**From:** Michael Eastham  
**Sent:** 13 June 2018 11:51  
**To:** Planning.Responses  
**Subject:** FW: The Lillies, Yapton Road, Barnham

Sketch Layout - 01

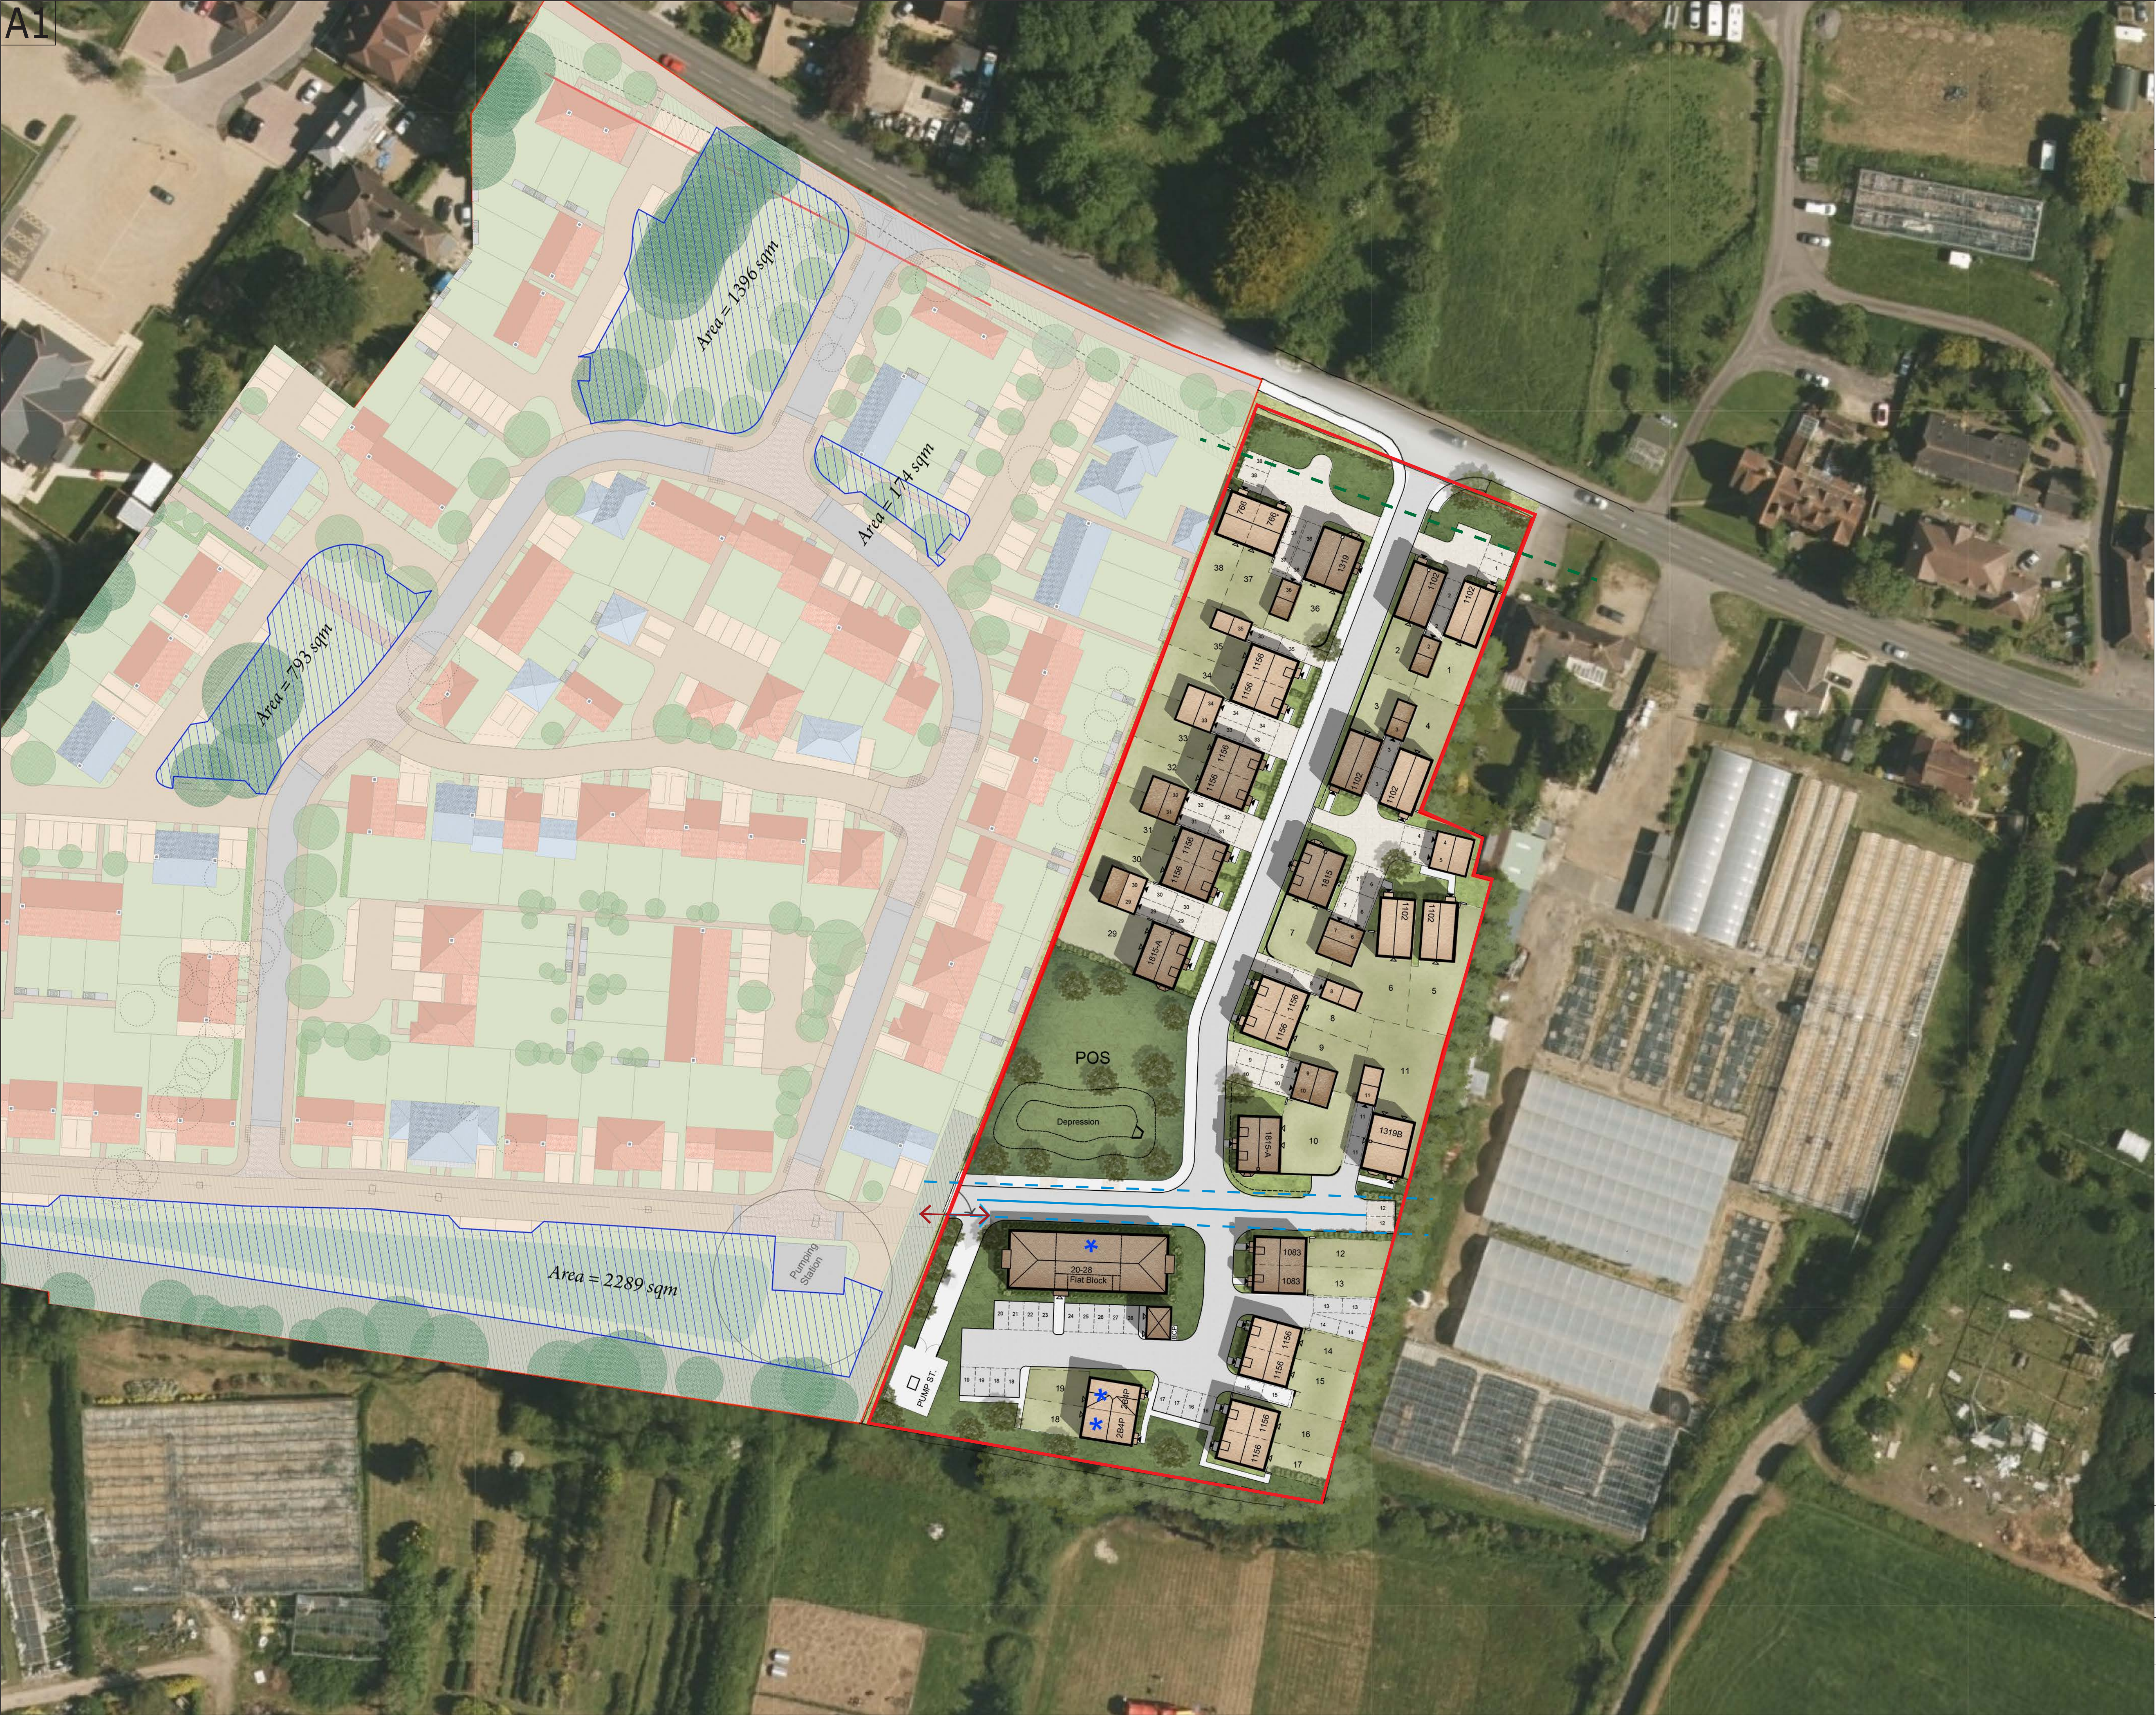
In response to the latest revised layout the LPA is encouraged that thought has been given to placing the Public Open Space (the POS) more centrally within the proposed residential development and the SuDS is now not taking the large proportion of this as previously shown.

However, the LPA is not convinced by the positioning of the SuDS in such close proximity to the apartment building 18-26 and also now seemingly tucked away in a corner and not integrated in a beneficial way with the surrounding site.

The incorporation of a sufficient area of POS and SuDS area within this proposed development continue not to be the subject of 'good design' and both appear to be being treated as an unnecessary inconvenience.

DETAILS DRAINAGE STRATEGY

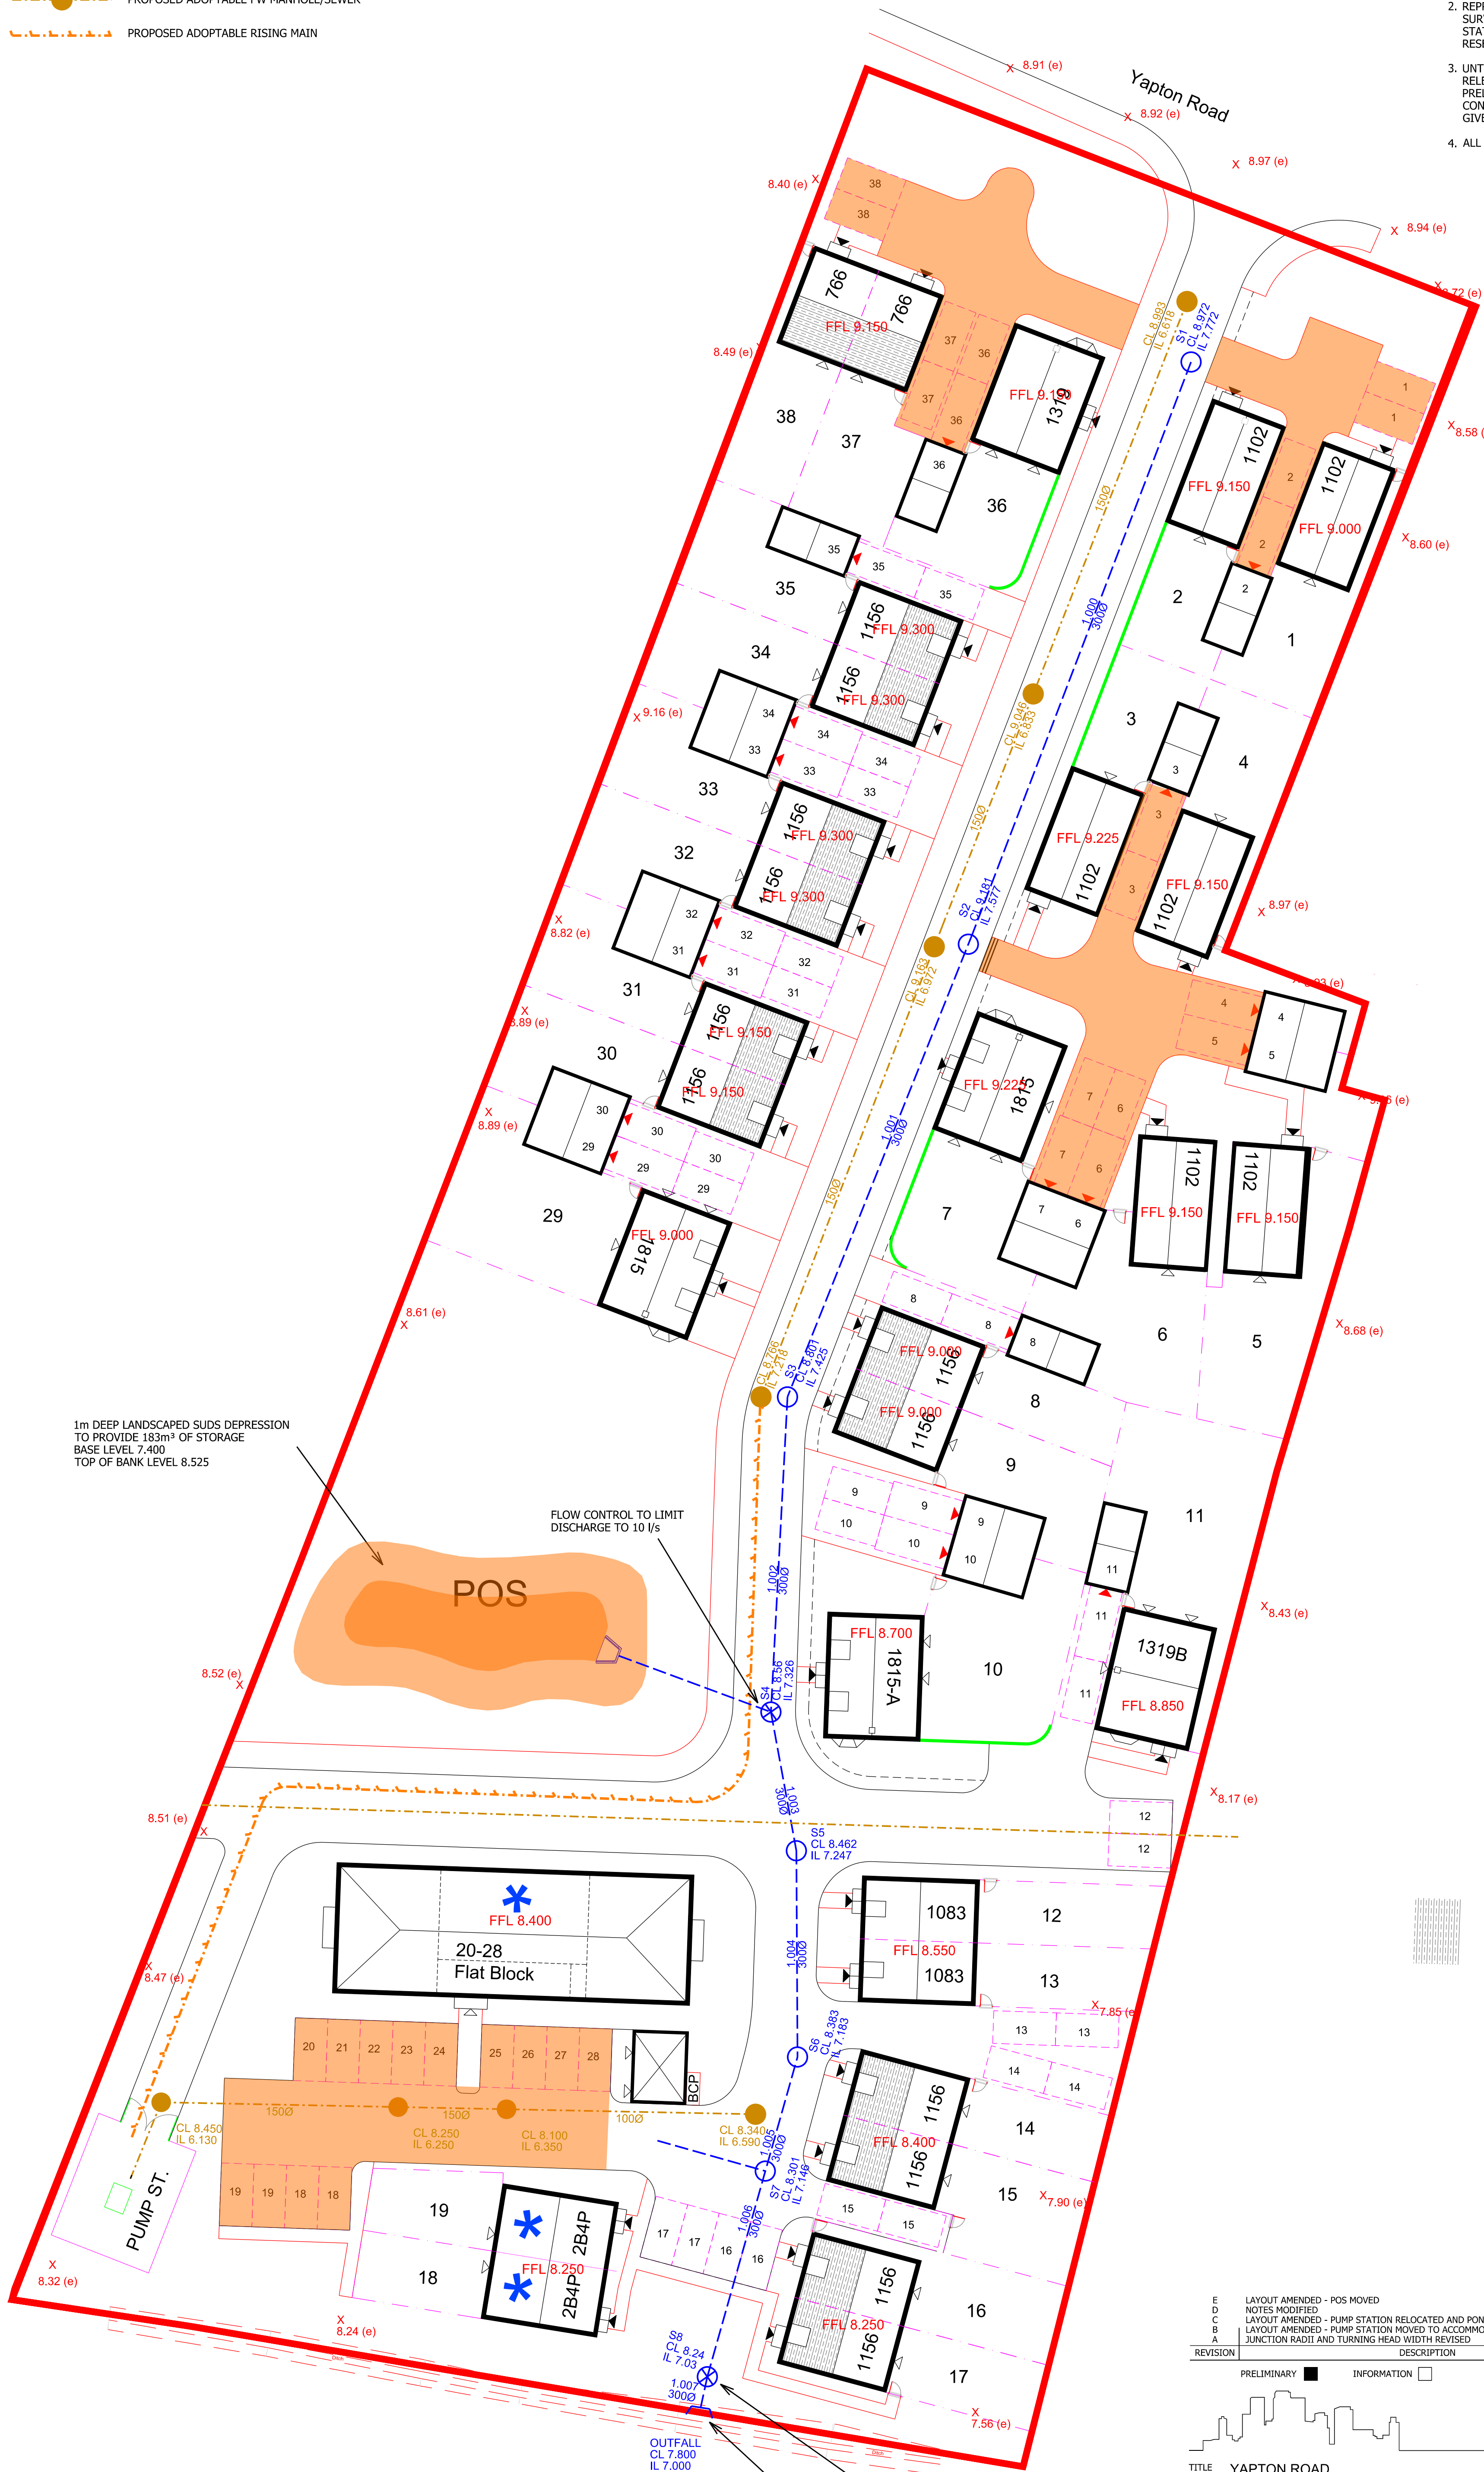
In terms of drainage, the discharge rate from the site will need to be limited to the 1 year greenfield run-off rate of 2.9 litres per second. More permeable paving areas are required, i.e. permeable paving for all parking areas; to ensure sufficient treatment is achieved. It is unclear from the new layout if the pond is now providing online or offline storage. Could the attenuation pond be made online rather than offline, with a low flow channel through the middle? The ditch downstream will require regarding. A minimum of 3 metres easement is required to all ditches to enable future maintenance. Full construction detail drawings will need to be submitted with formal Discharge of Condition (DOC) applications.
